From: Julie Grieves on behalf of Planning.Responses
Sent: 14 June 2019 08:35
To: Planning Scanning
Subject: FW: Objection A/55/19/PL
Attachments: Bungalows A5519PL.pdf

From: james mimpriss [REDACTED]
Sent: 13 June 2019 16:44
To: Anita Gardner
Subject: Objection A/55/19/PL

I object to A/55/19/PL for the same reason as A/31/19/PL with few additional material reasons.

Site Location Plan (1:1250)

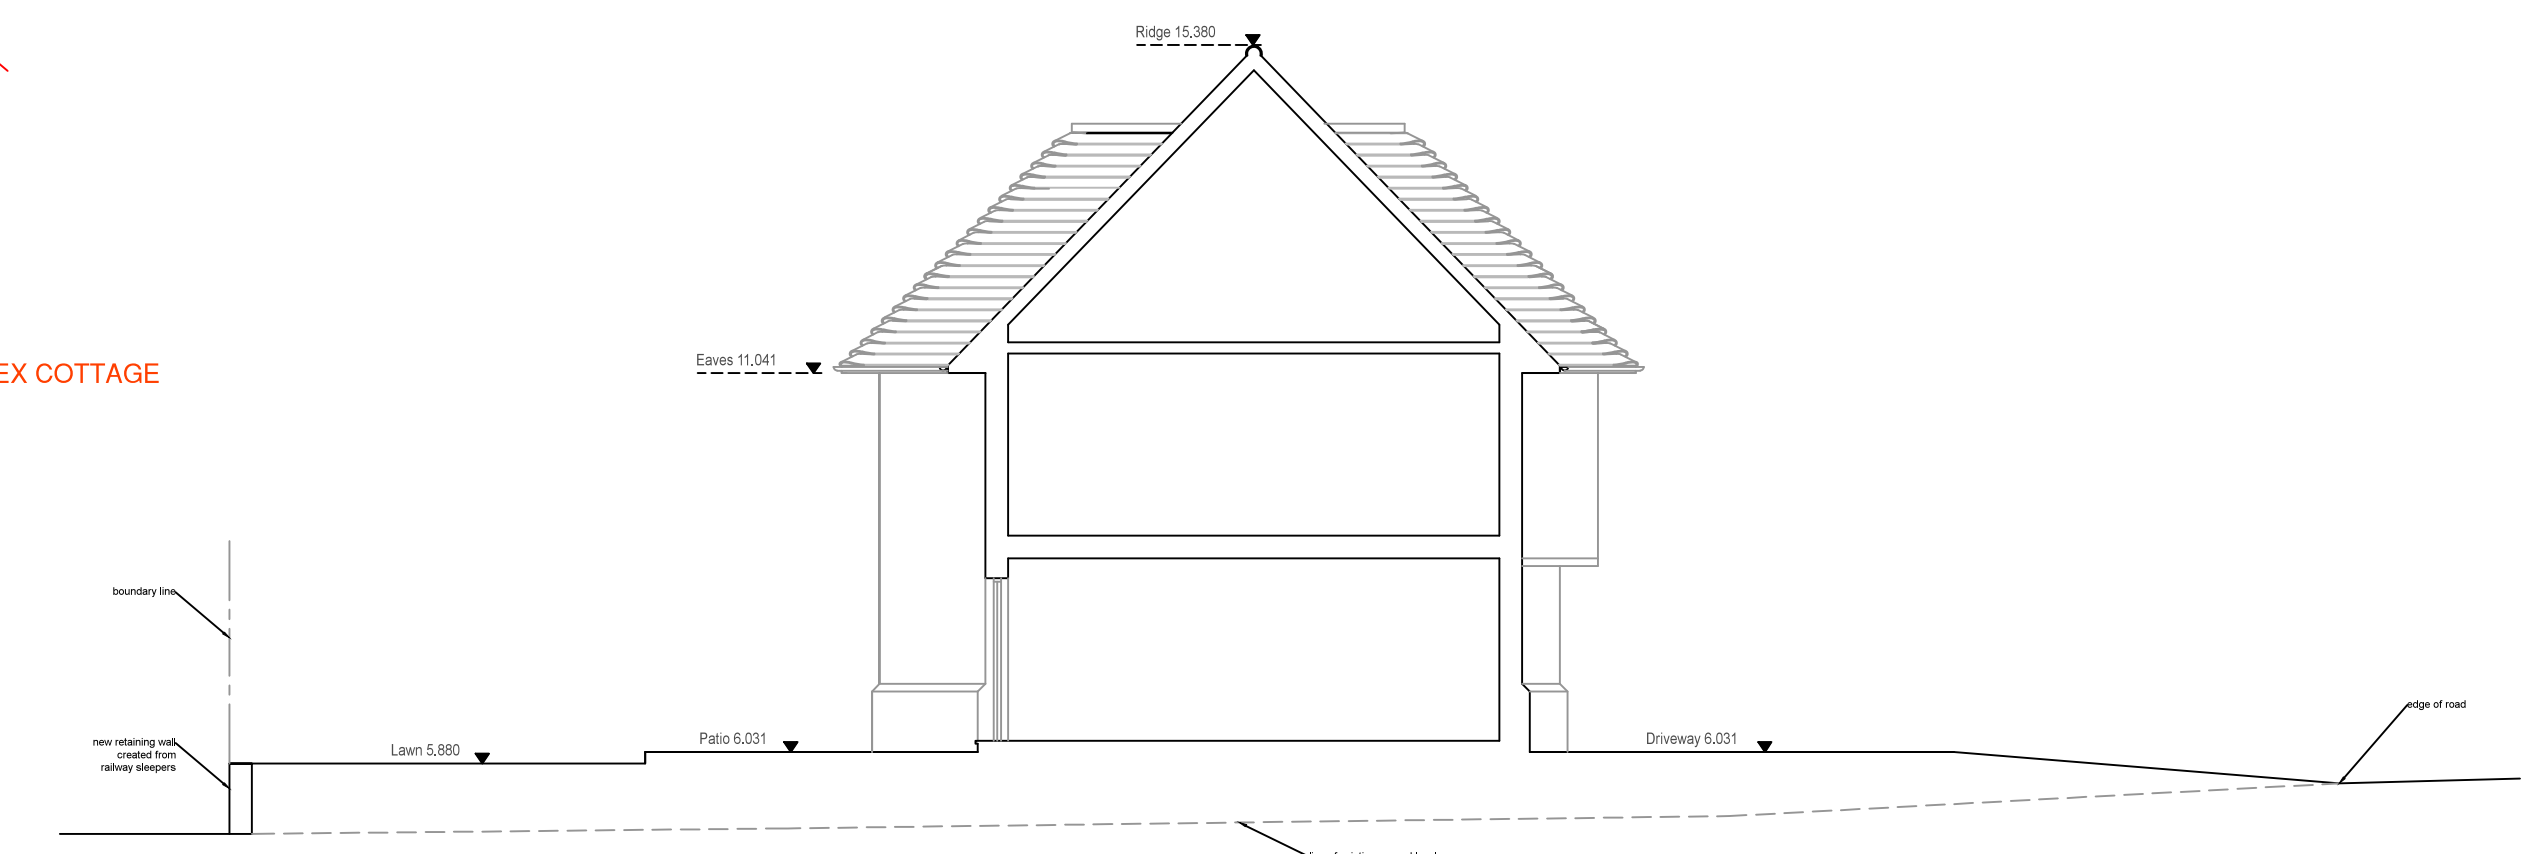
As shown on the submitted plan drawing, drawing number 1202.02.c, the proposed property is positioned a long way forward of the historical build line which can be seen from aerial photo's on Google map. On both sides of Ham Manor Way there is a defined line where properties are not built in front of. This again demonstrates the property is too big for the plot size whilst trying to gain a back garden.

Client: Mr & Mrs Jones
Project Address:
Land at the 9th Tee
Ham Manor Way
Angmering
Drawing Title:
Proposed Plans, Elevations and Street
Scene Elevation
Drawing Number: 1202.01.d
Scale: As stated printed @ A1
Date: 06/02/2019

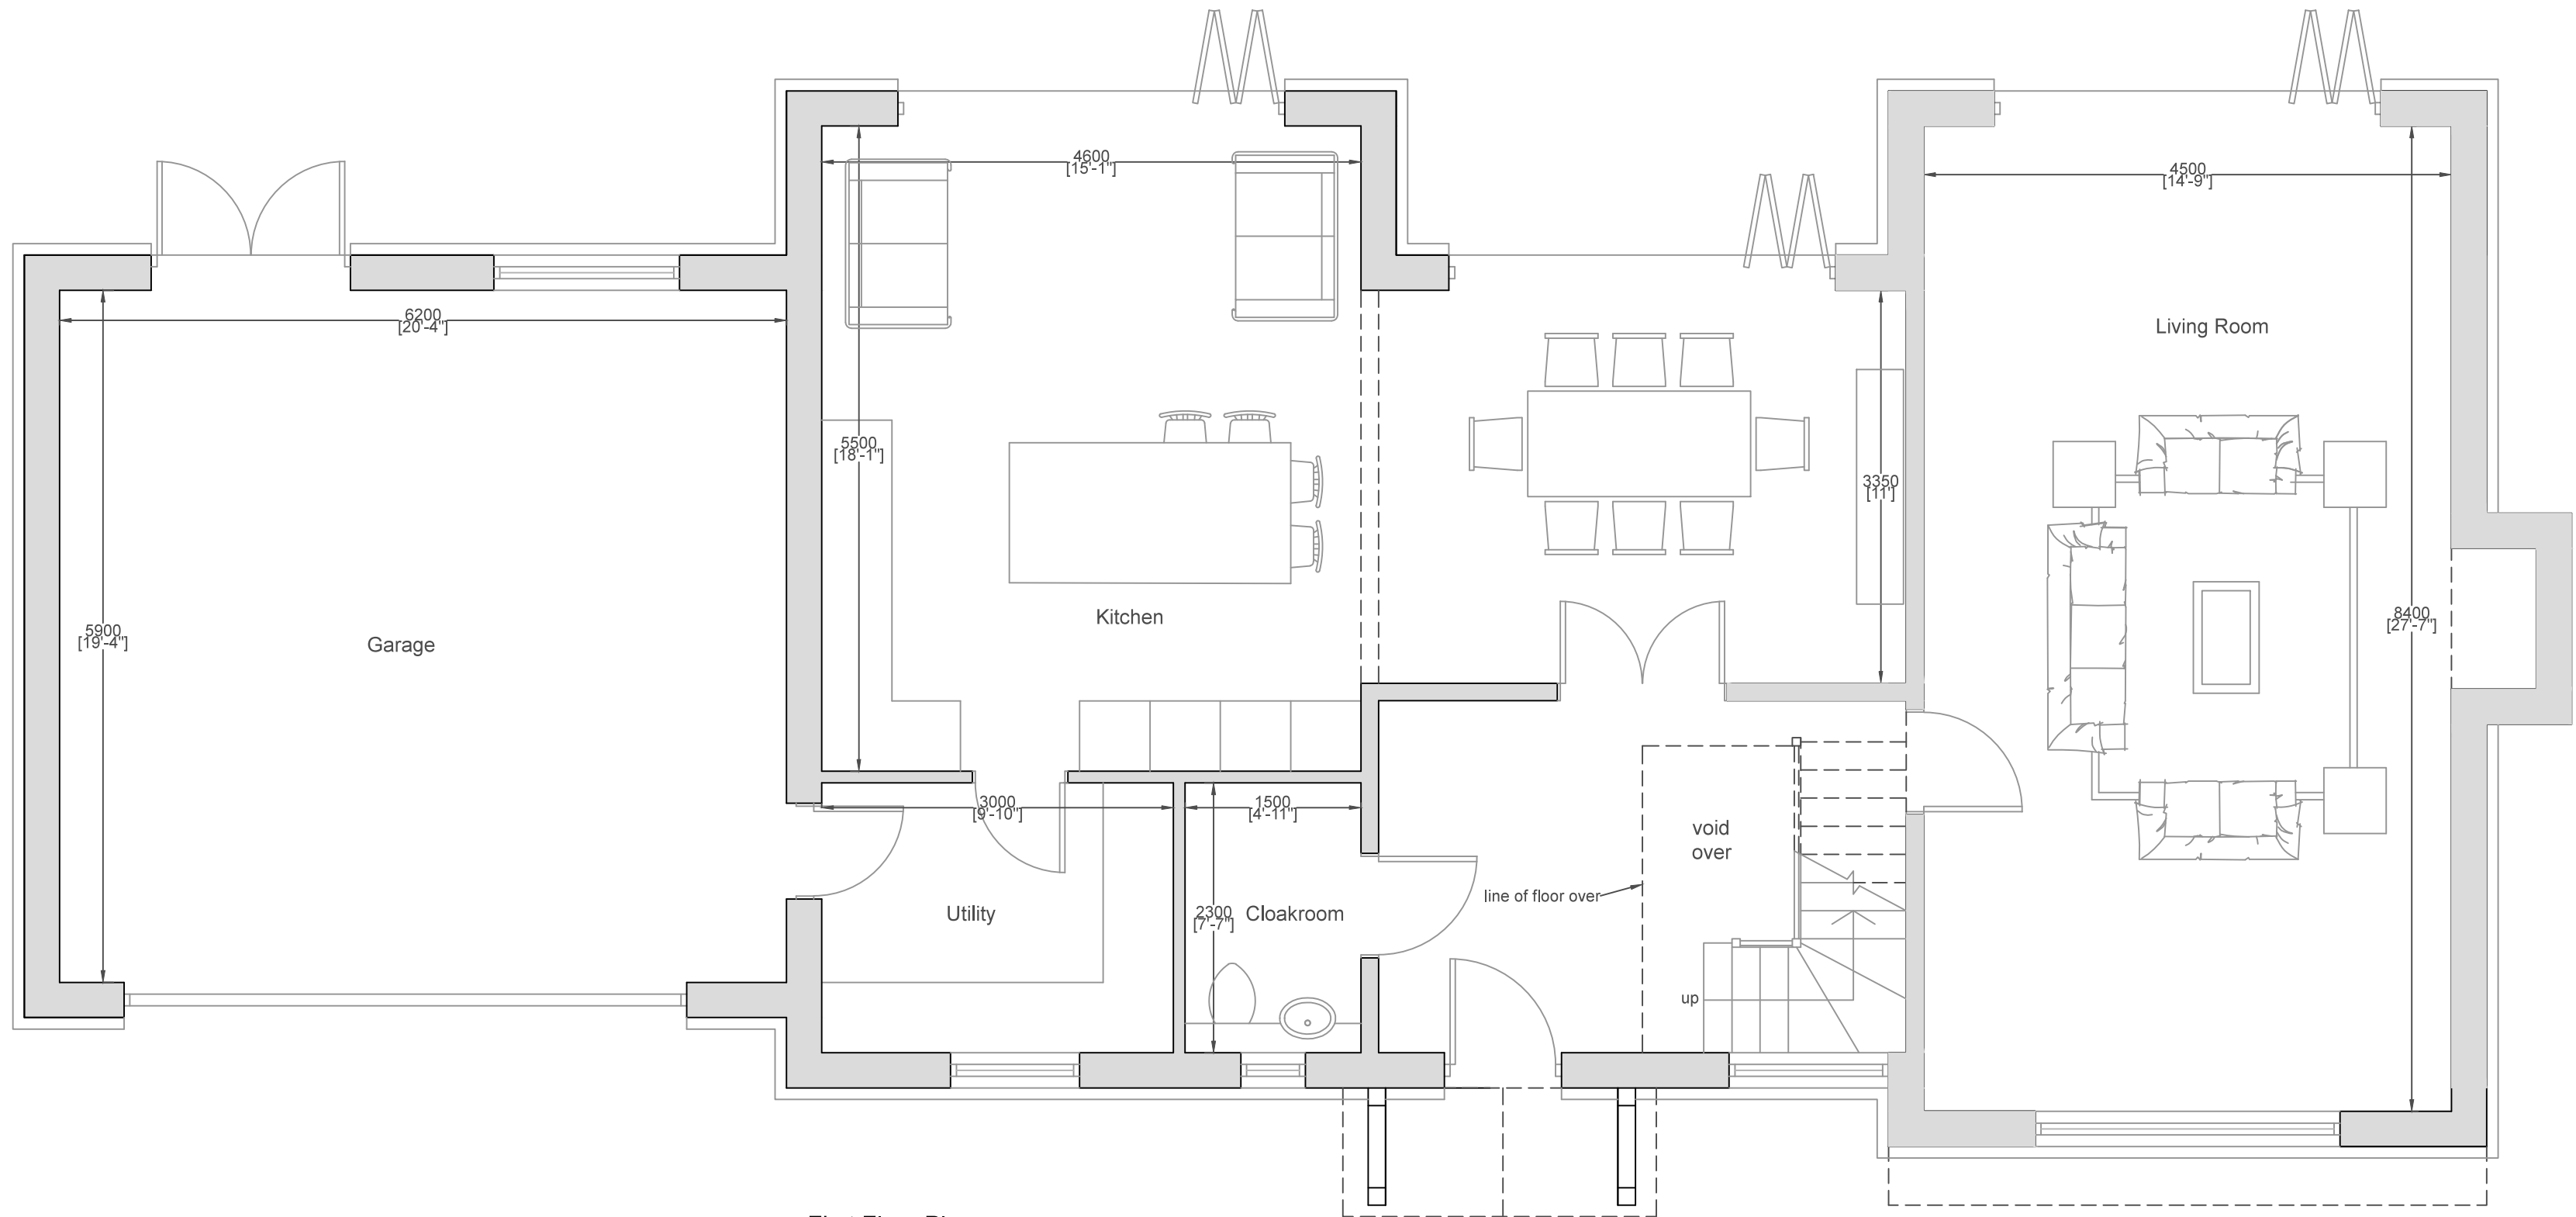
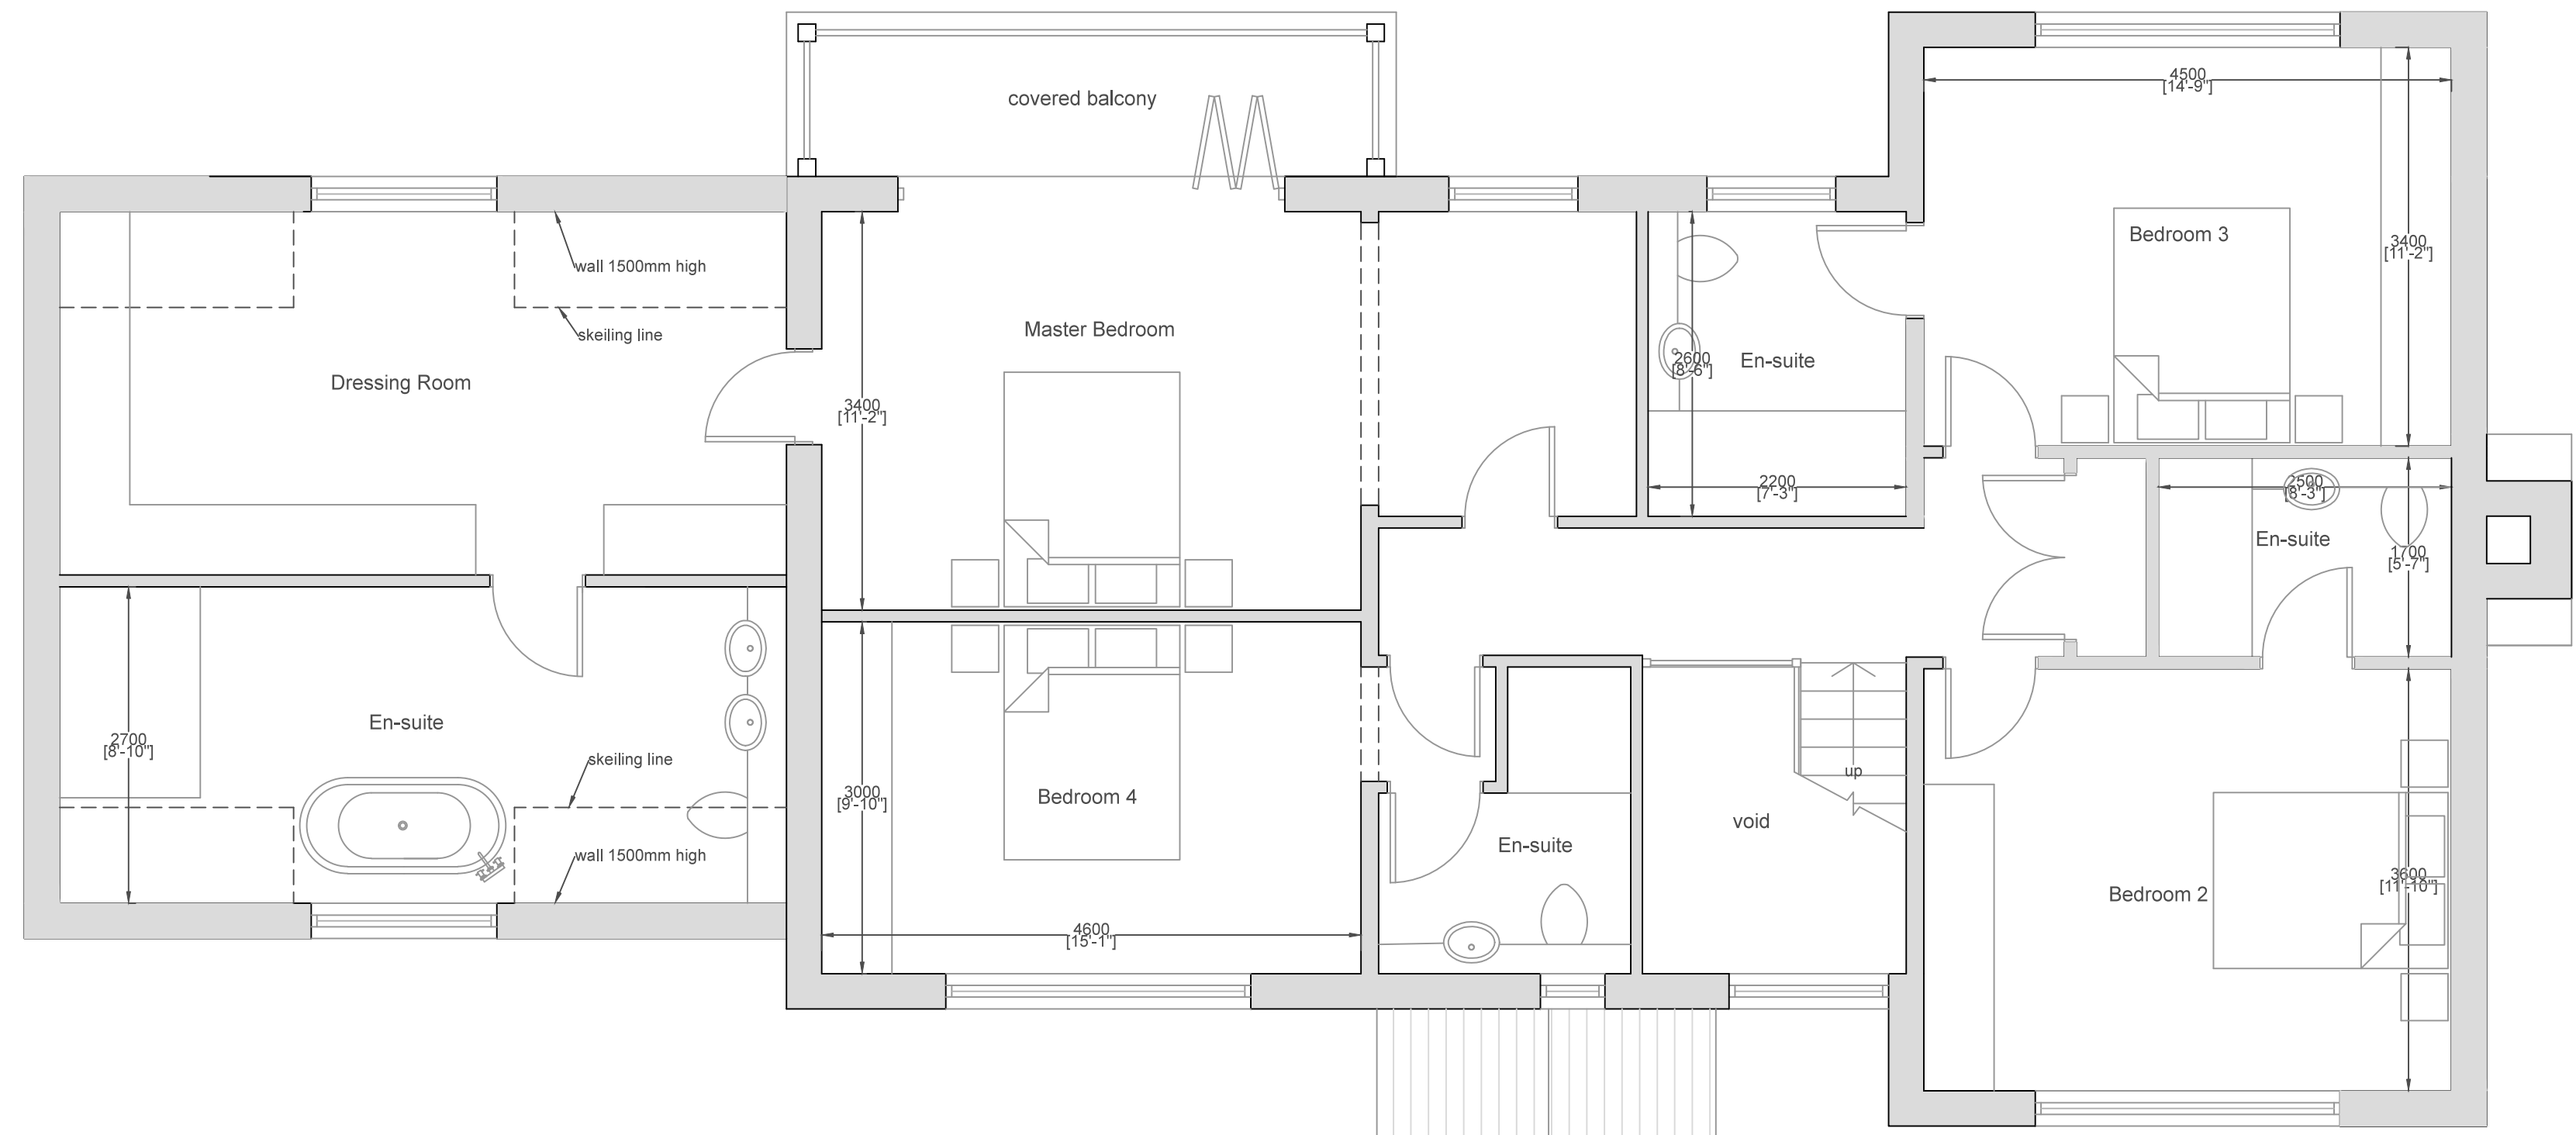
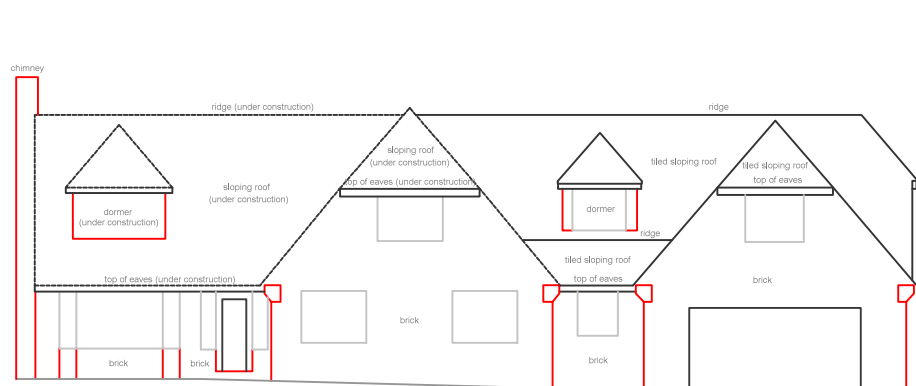
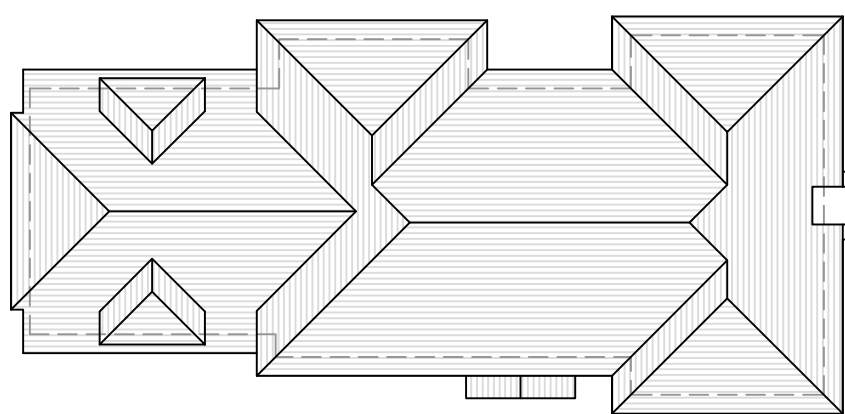
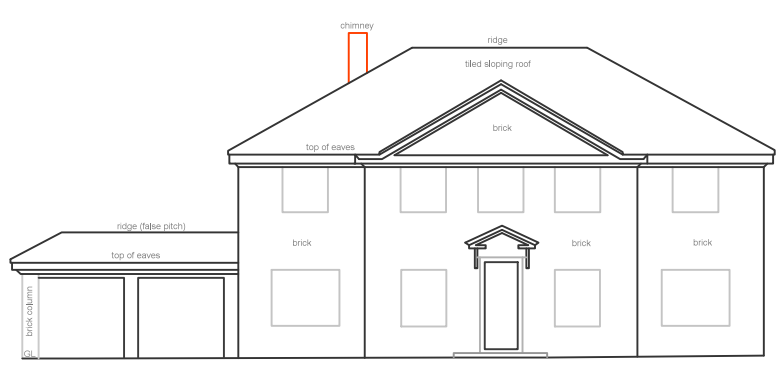
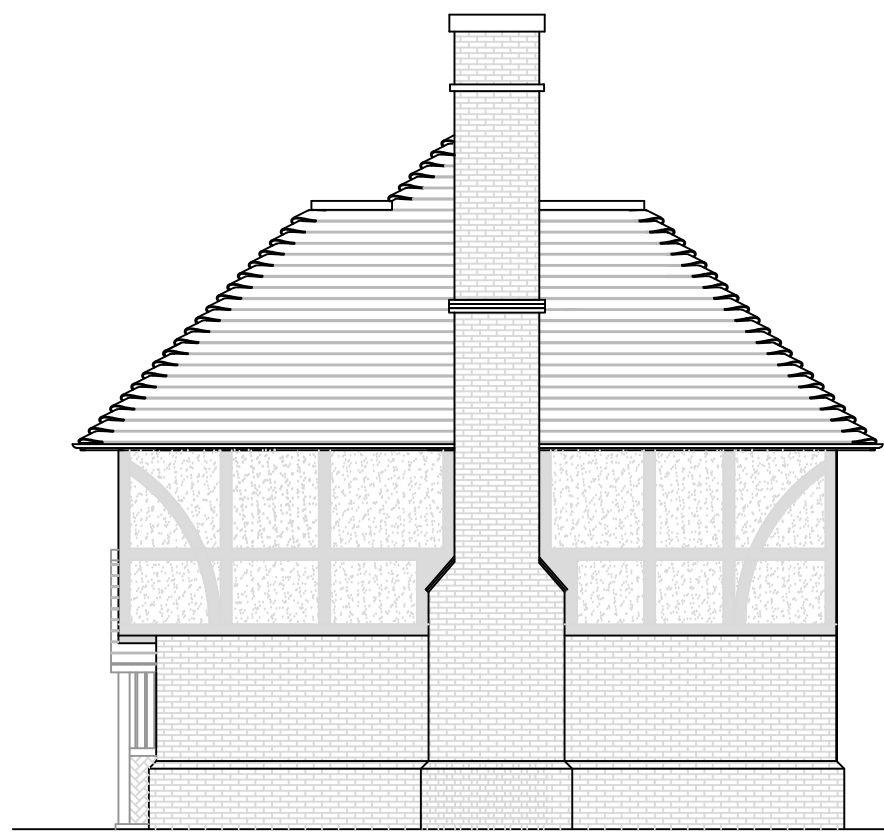
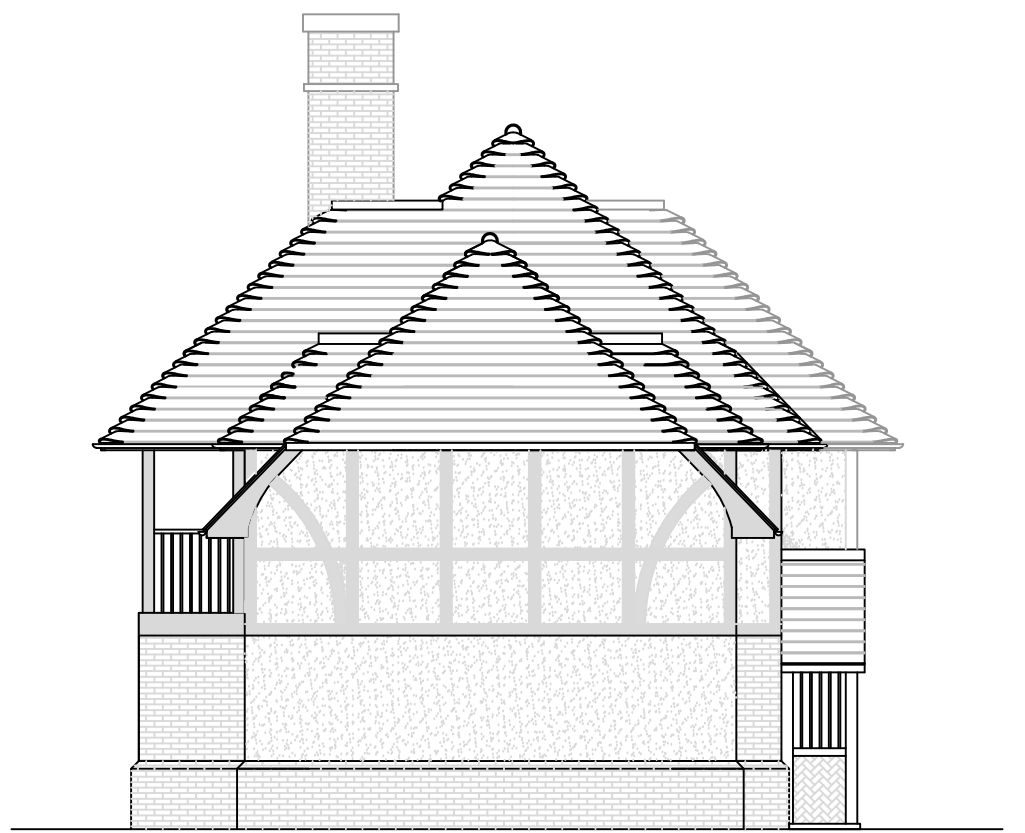
The proposed property is too big in itself for the plot size bearing in mind it's one of two units, Street scene and Build form. It claims it the same area as Badgers but on a much smaller plot. Arun's recommendation report , A/31/19/PL, reference design quoted the following " However whilst the design of the dwelling is considered acceptable the proposal would adversely affect the character of the area and is therefore contrary to policy." This is the same property design and size as the refused A/31/19/PL.

In the same document under NEIGHBOURHOOD CONSIDERATION it states there are no side facing first floor windows, if planning is allowed then this should be enforced on the permission for both first floor and ground floor to prevent overlooking neighbours to the SW and NE with a material change later.
